**PROPOSED RESIDENTIAL DEVELOPMENT, CHEQUERSFIELD, WELWYN GARDEN CITY  
NOISE ASSESSMENT ADDENDUM – RESPONSE TO EHO COMMENTS  
SEPTEMBER 2018  
OUR REF: 22573/09-18/6271**

Mewies Engineering Consultants Ltd (M-EC) has been commissioned by Taylor Wimpey (North Thames) to provide an addendum to the Noise Assessment produced for the planning application for a small section of land off Chequersfield, Welwyn Garden City. Planning Permission 6/2018/1519/MAJ is concerned with the “...erection of 30 residential units and associated vehicular access, associated ancillary and enabling works”.

A full noise assessment for this planning application was produced in May 2018 (M-EC report ref. 22573/05-18/5014). Comments have been received by the Environmental Health officer, regarding a number of items within this report, namely:

Dwg. No. LSD209-02-01 Rev: F
 Rev E: Balcony doors amended to open inwards.
 Rev F: Updated to suit revised layout.

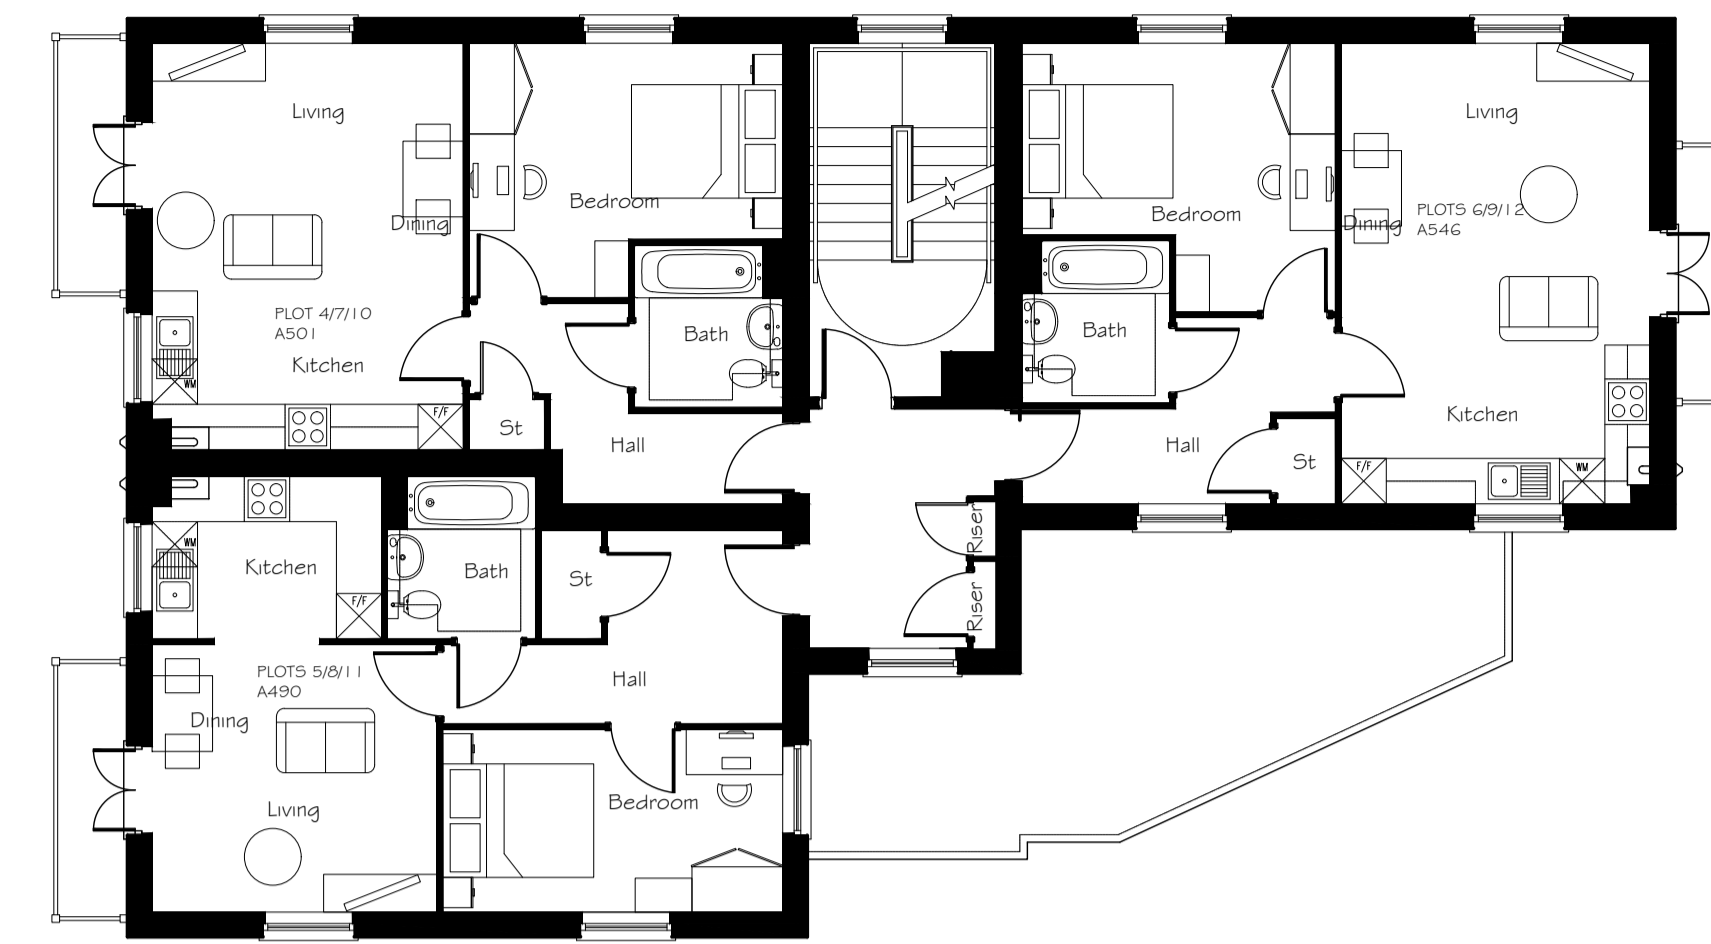
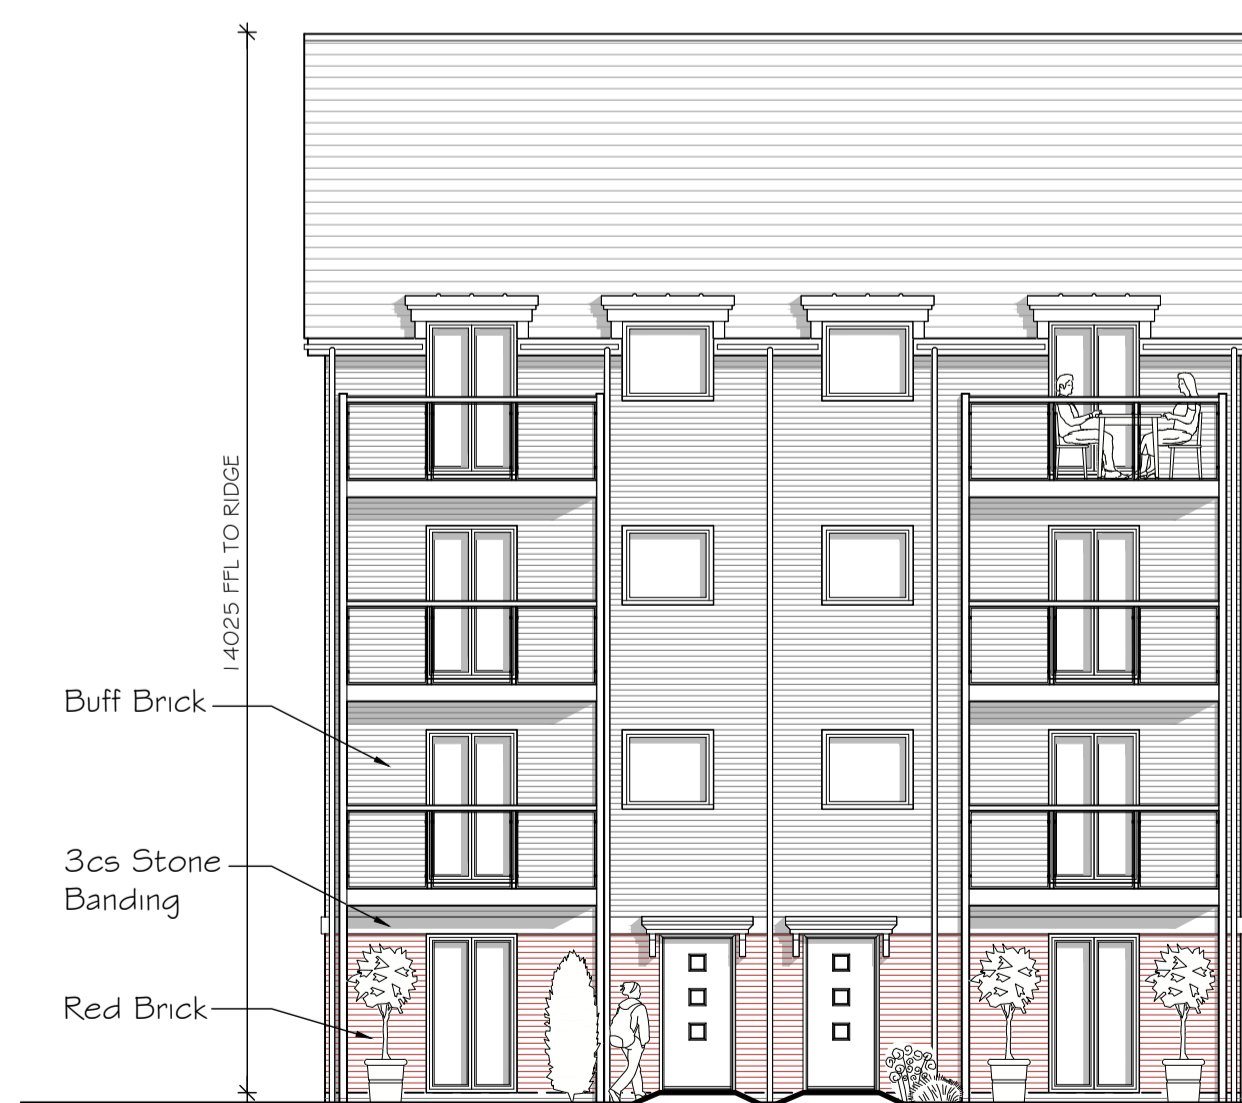
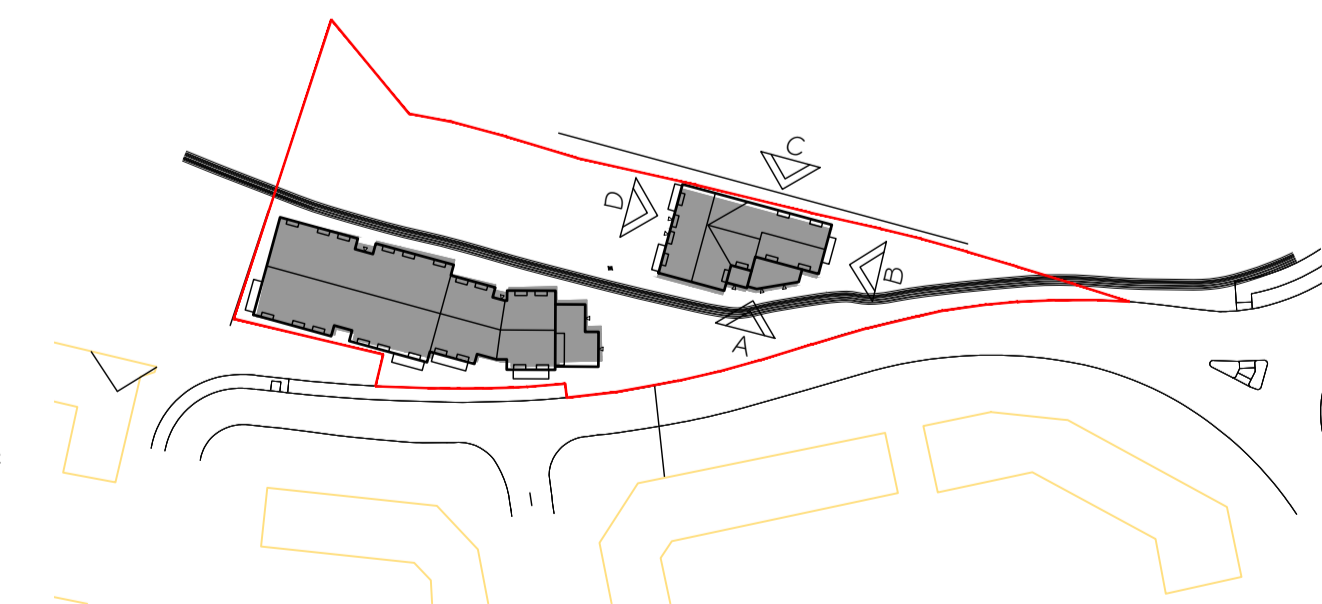
*There is some confusion over the design of the development. The acoustic report states that there will be no balconies. However, other information now states that there will be balconies, and close to noise sources.*

*The outdoor amenity spaces, in this case balconies will need to meet the 55 dB WHO Guidelines for Community Noise and we would expect information to be provided to support this.*

Based upon Drawing number LSD209-02-01 Rev E, it appears that there are a number of balconies facing towards the railway line. The results of our recent monitoring, at Positions 1 & 3, indicate that the 55 dB(A) limit, as specified by BS8233: 2014 and WHO Guidelines for Community Noise, will not be exceeded, as indicated in Table 1 below:

Position 1 was located at the western corner of the site. Position 3 was located at the eastern corner of the site, along the northern boundary. As Position 1 was located at the closest point on the site to the railway line, it can be seen that even if the balconies were located at the extreme western point on the site, closest to the railway line, the measured average noise levels do not exceed the upper limit of the external amenity space noise level guidance within BS8233: 2014 and WHO Guidelines for Community Noise. Therefore, there is no reason, based upon the measured results, why balconies cannot be located here.
